Capital Place (Ref. 36728/APP/2025/3224) – 15/04/26

Design Comments – Applicant Response

Comments from London Borough of Hillingdon’s Design Officer were received on the 13th of February 2026. The revised submission contains updated plans, a Design and Access Addendum (Ref P02) and CGI imagery in response to officer’s comments.

Drawing No:	CCL 12427 / IAP Rev: 1
Title:	Impact Assessment Plan
Site:	Capital Place UB3 5AN
Scale:	0 5 10 15 20m 1:2400

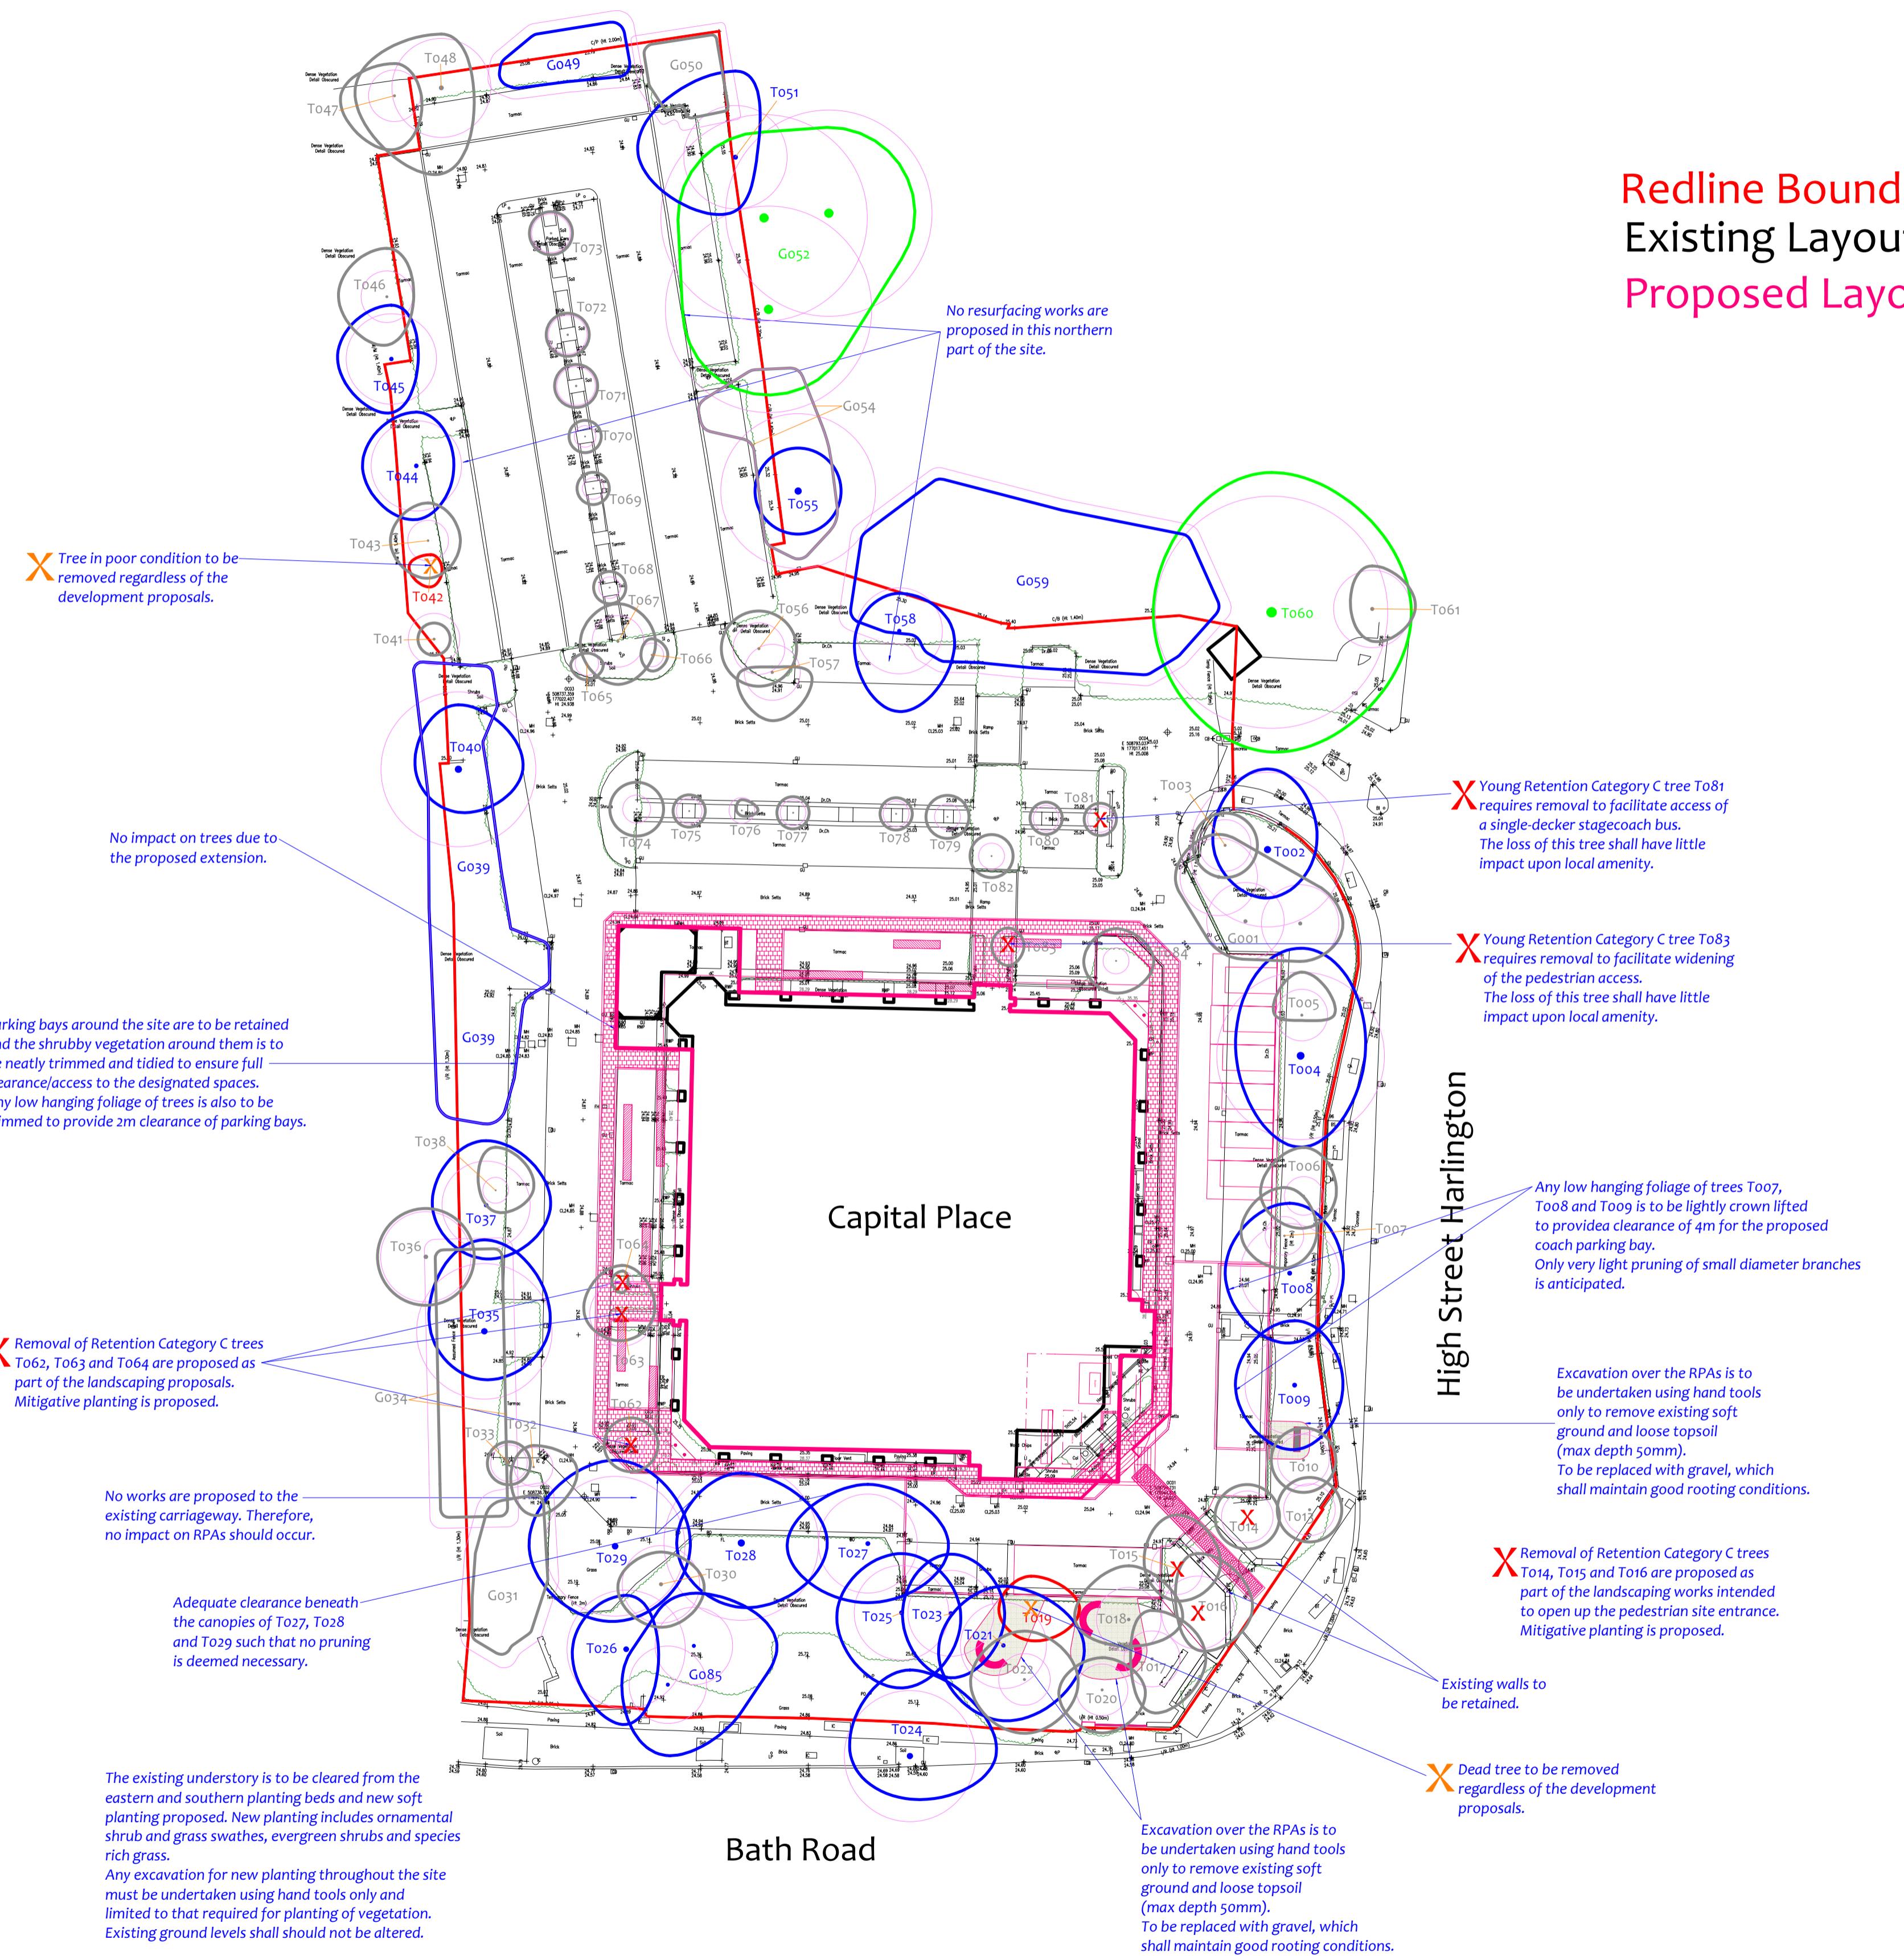
<p>The proposed hard-surfacing within the Root Protection Areas (RPAs) of existing mature trees raises significant concerns regarding their long-term health. Could these areas of hard-standing be omitted or relocated — potentially into the extensive car parking area</p>	<p>The scheme has largely been developed within the existing parameters on site, including the current areas of hardstanding – see attached topographic survey overlay in blue. The design intent is that the majority of the existing trees to Bath Road and High Street</p>

— to ensure these trees are preserved? Given their role in softening the Bath Road streetscape, it is essential that these mature specimens are protected and, where necessary, supplemented with replacement planting should any existing trees be in decline.

Harlington are retained, along with the alignment of the areas hardstanding. That way we can work within the parameters on site whilst limiting any additional impact to the tree roots. Most of the trees along these edges are fairly mature, ranging from moderate to good, and have established in and around the existing surfacing so we believe any additional impact will be moderate if at all. No new buildings are proposed in the root protection areas.
